# CITY OF ALBUQUERQUE

**Re: Village at Avalon  
Erosion Sediment Control Plan  
Engineer's Stamp Date 1-22-16 (K09E040)**

Based upon the information provided in your submittal received 1-27-16 the above referenced plan cannot be approved for ESC Permit or Work Order until the following comments are addressed:

Village at Avalon

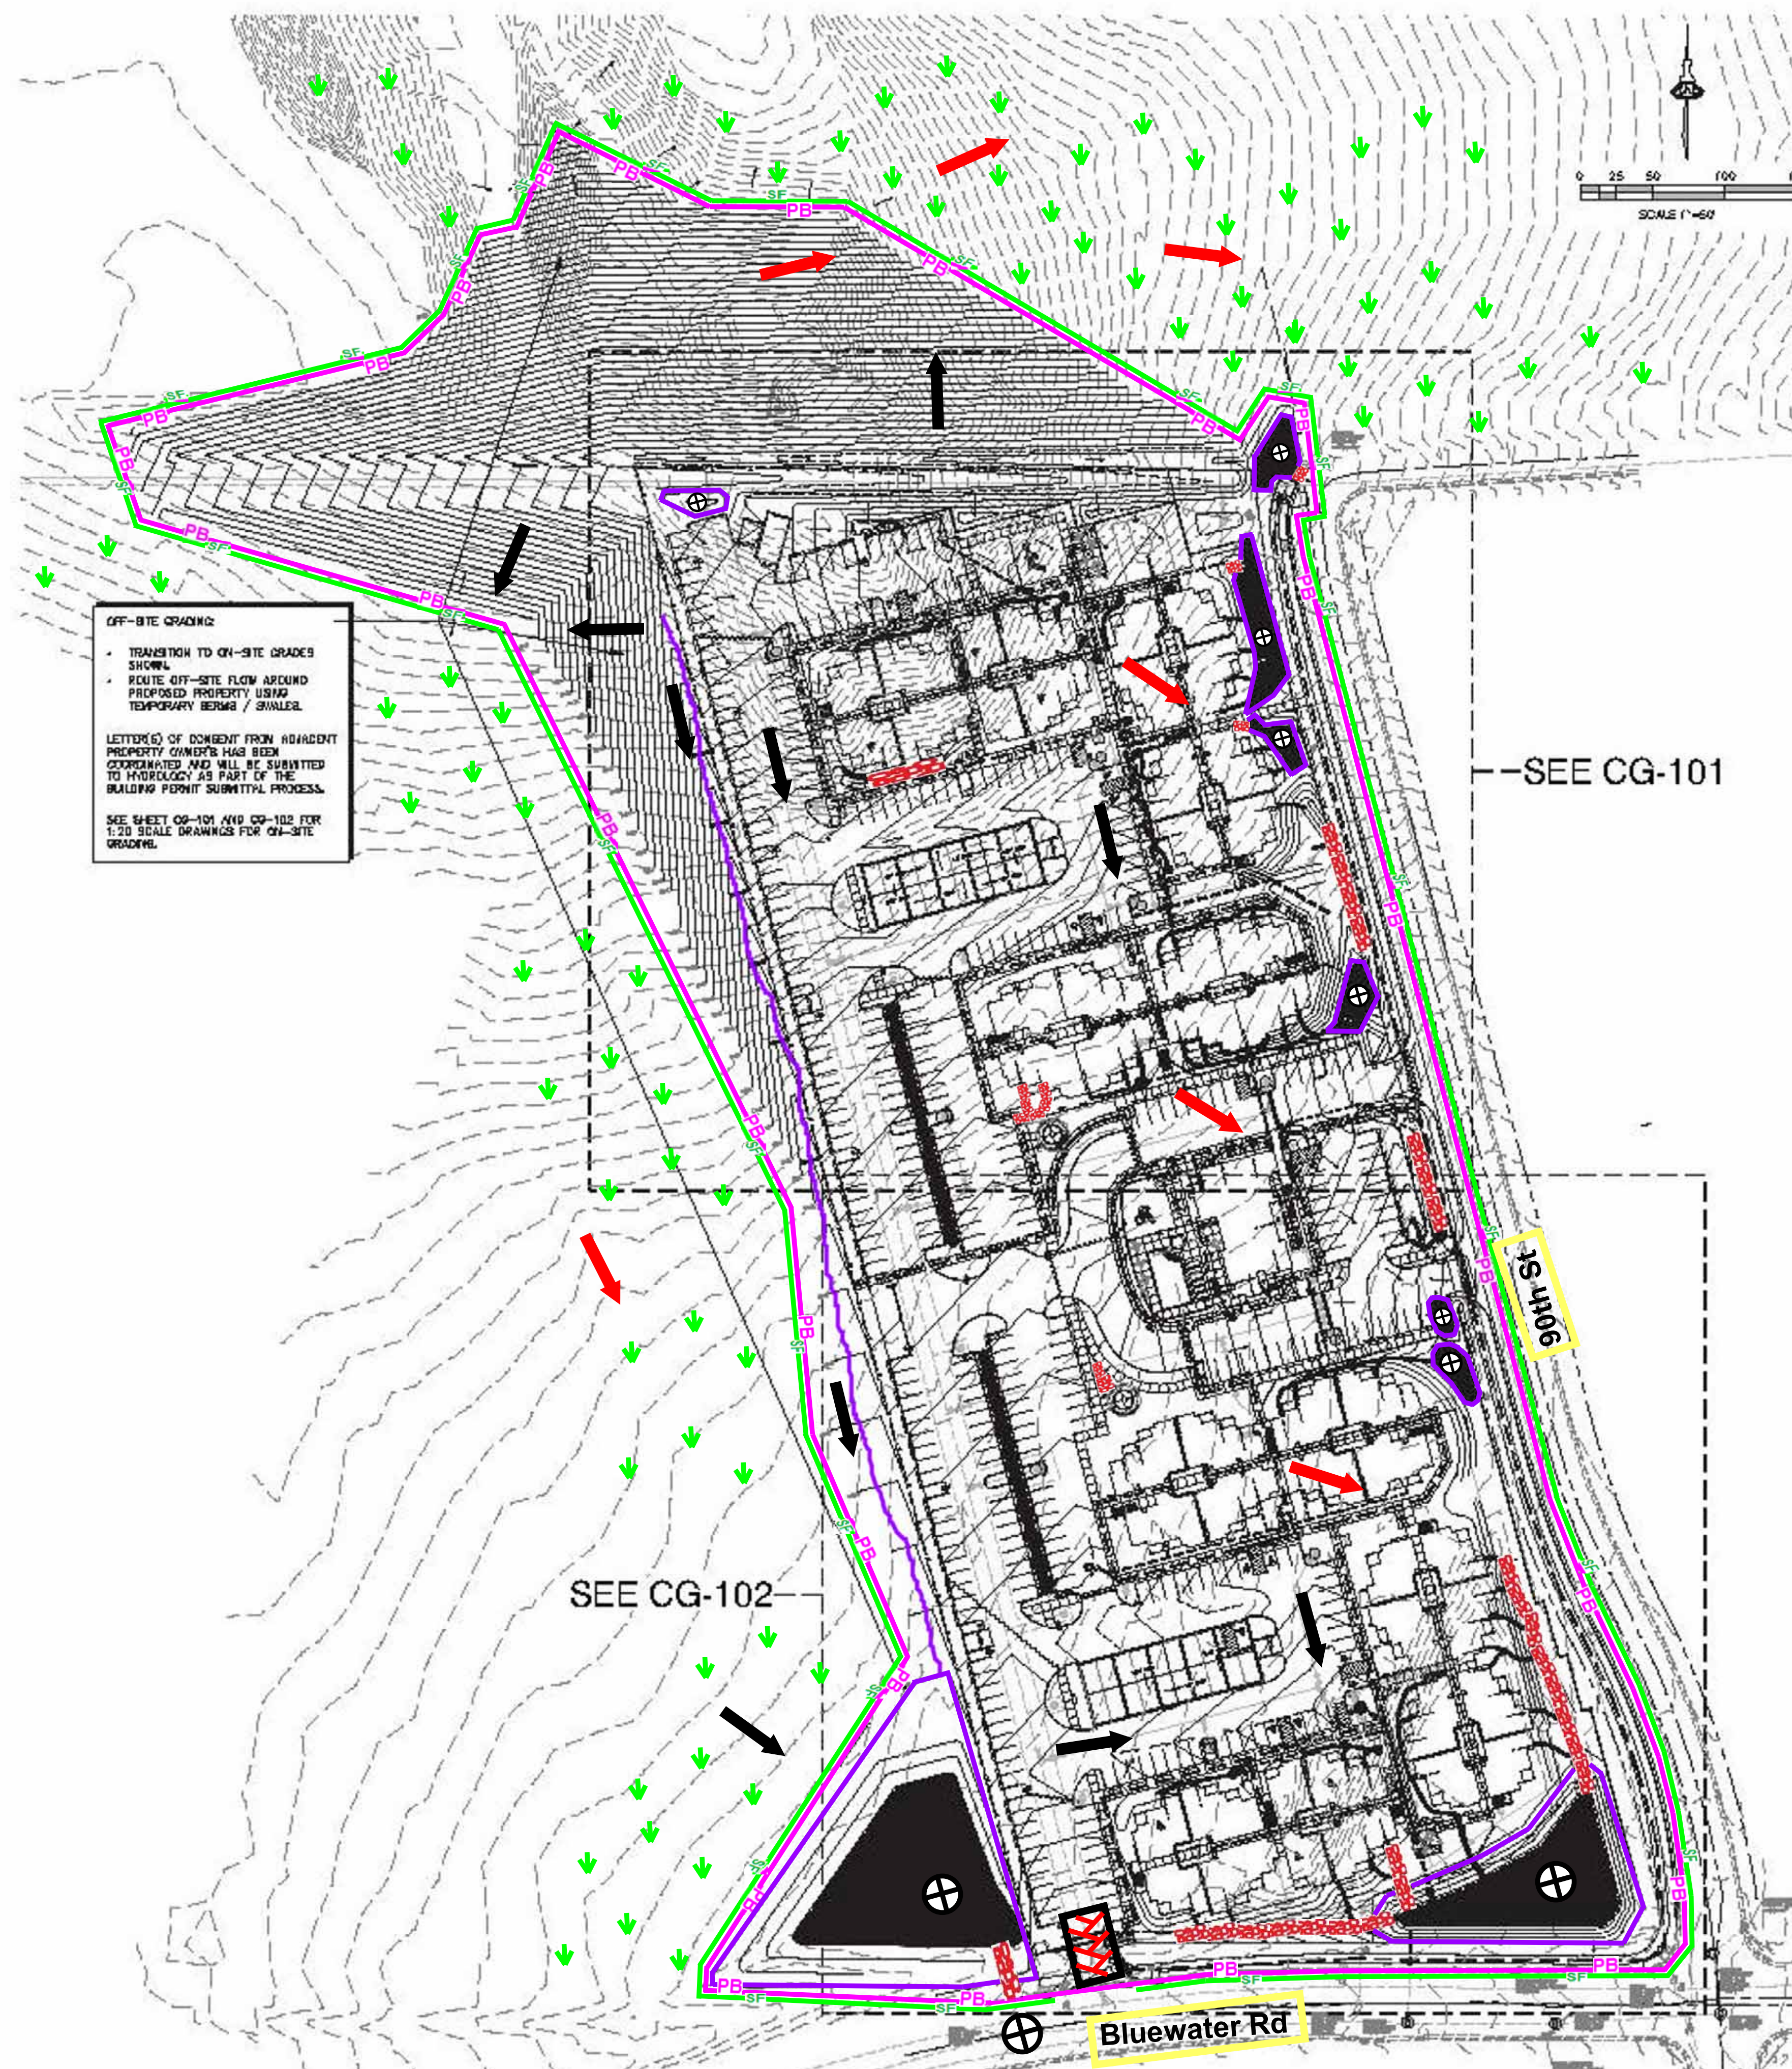
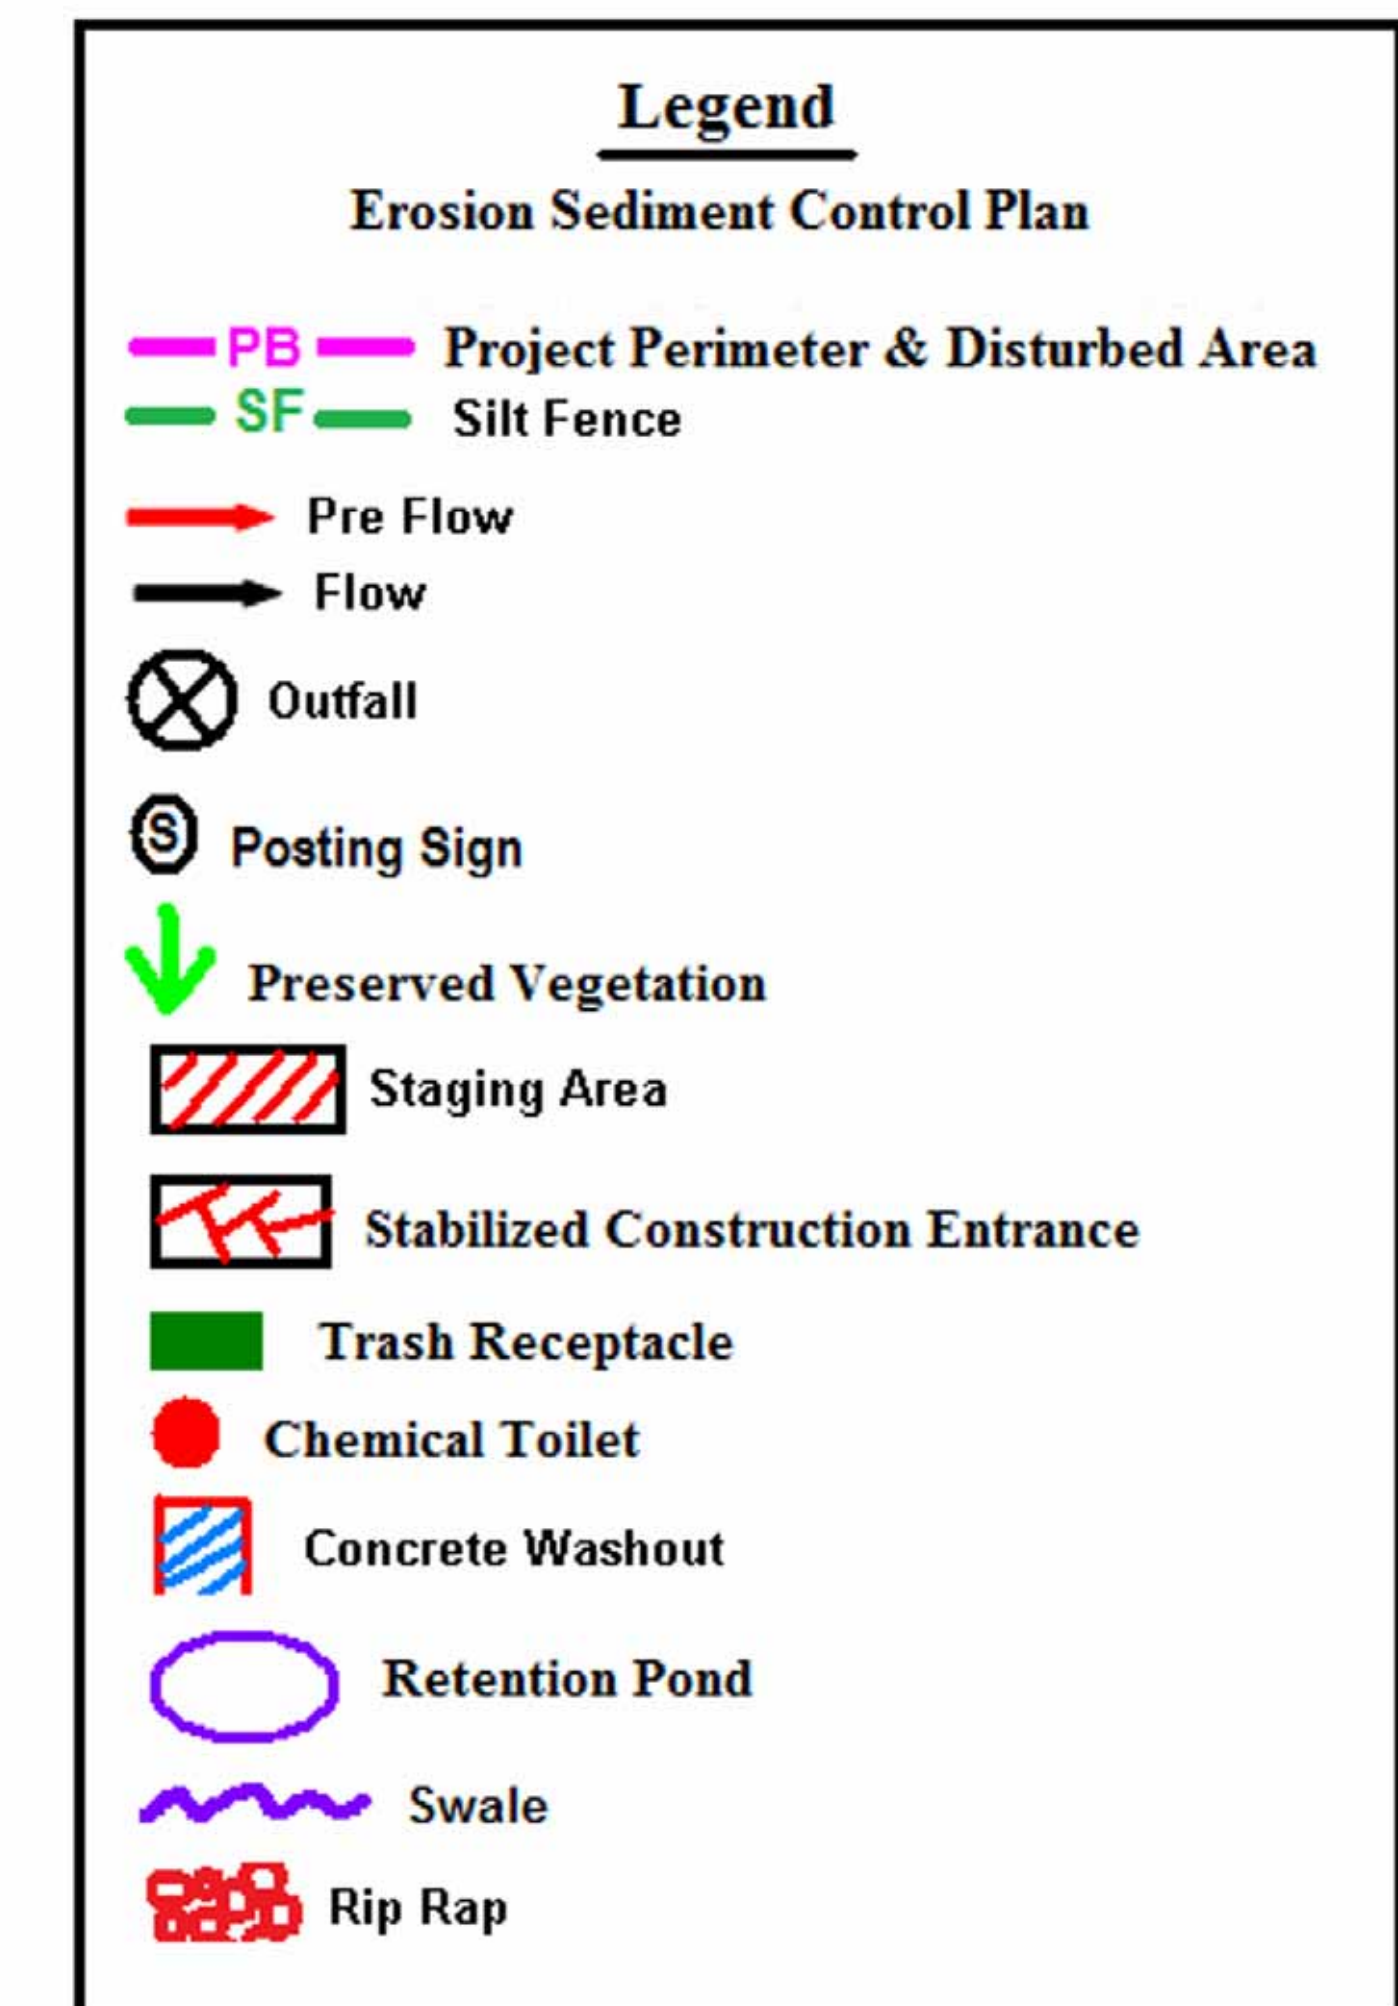
1. Add inlet protection for the outfall to the City system at the south end of the site.

1. Please add a note or similar that when doing work in the City ROW (sidewalk, storm drain, drive pads) to avoid dirt from getting into the street.

2. This project will most likely have a street cut for water and sewer. If so, please include a symbol for the dirt pile for the utility cut to be on the uphill side of the cut and to sweep the street when they are done.

3. It appears curb and gutter may be required on the west side of 90<sup>th</sup> St. Inlet protection (that allows high flows to enter, but traps sediment at low flows) should be added at the inlet at the south end of 90<sup>th</sup> St. on the west side.
